CITY OF ALBUQUERQUE

May 23, 2017

Re: TLC Plumbing & Utility Office- Warehouse
5000 Edith Blvd. NE
Traffic Circulation Layout
Architect's Stamp 2-17-17 (G15D032)

SITE PLAN

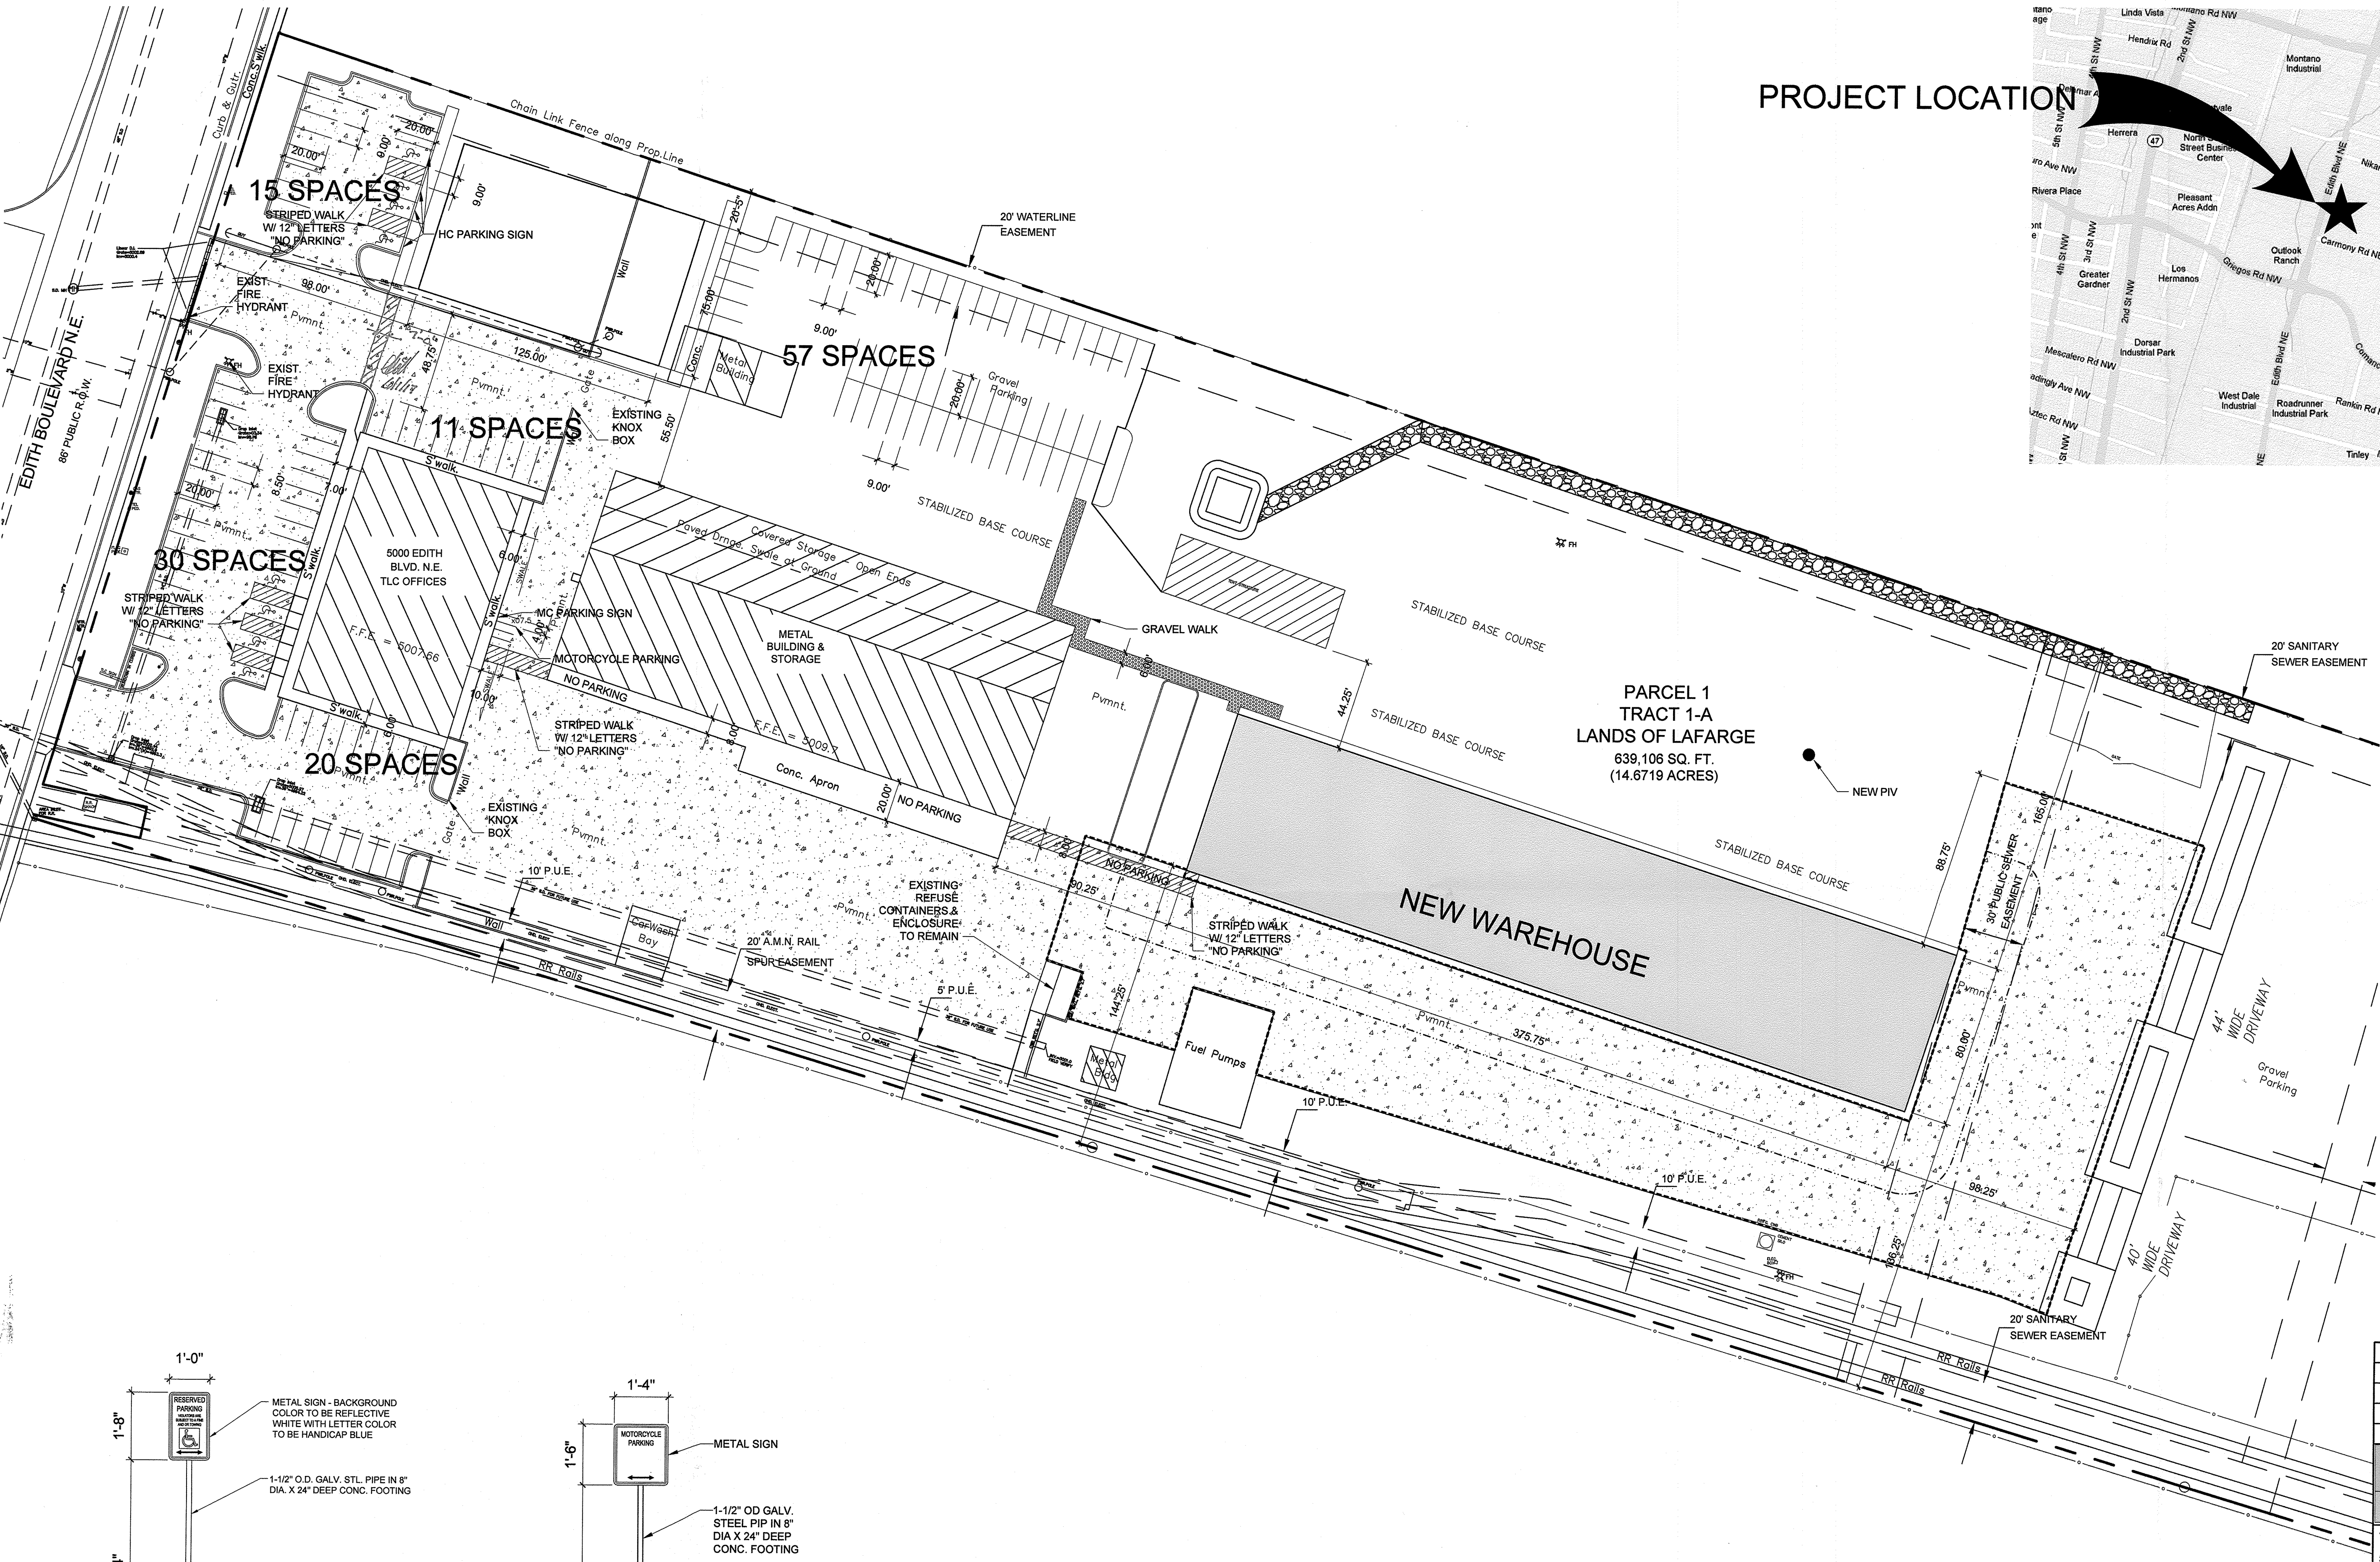
1. Please show a vicinity map showing the location of the development in relation to streets and well known landmarks.
2. Identify all existing access easements and sidewalk width dimensions.

3. Please list the width and length for all existing and proposed parking spaces. Some dimensions are not shown.
4. Clarify existing property lines and proposed property lines.

7. Please dimension all pedestrian path ways. Some dimensions are not shown.
8. Show all drive aisle widths and radii. Some dimensions are not shown.
9. Per DPM, a 6 ft. wide ADA accessible pedestrian pathway is required from the HC parking stall access aisles to the building entrances. Please clearly show this pathway and provide details.

10. Provide and clarify access on east end of the property 40' D/W and 44' D/W.
11. Provide access aisles from the new parking to the new building. Please clearly show this pathway and provide details.

A1 HC SIGN

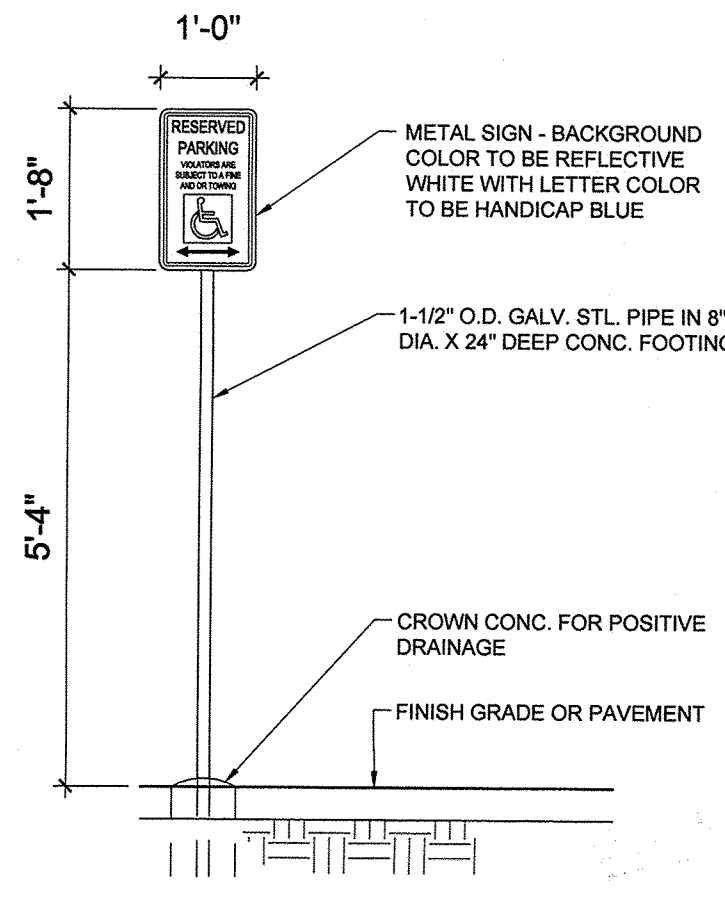
5. The ADA accessible parking sign must have the required language per 66-7-352.4C NMSA 1978 **"Violators Are Subject to a Fine and/or Towing."** Please call out detail and location of HC signs.
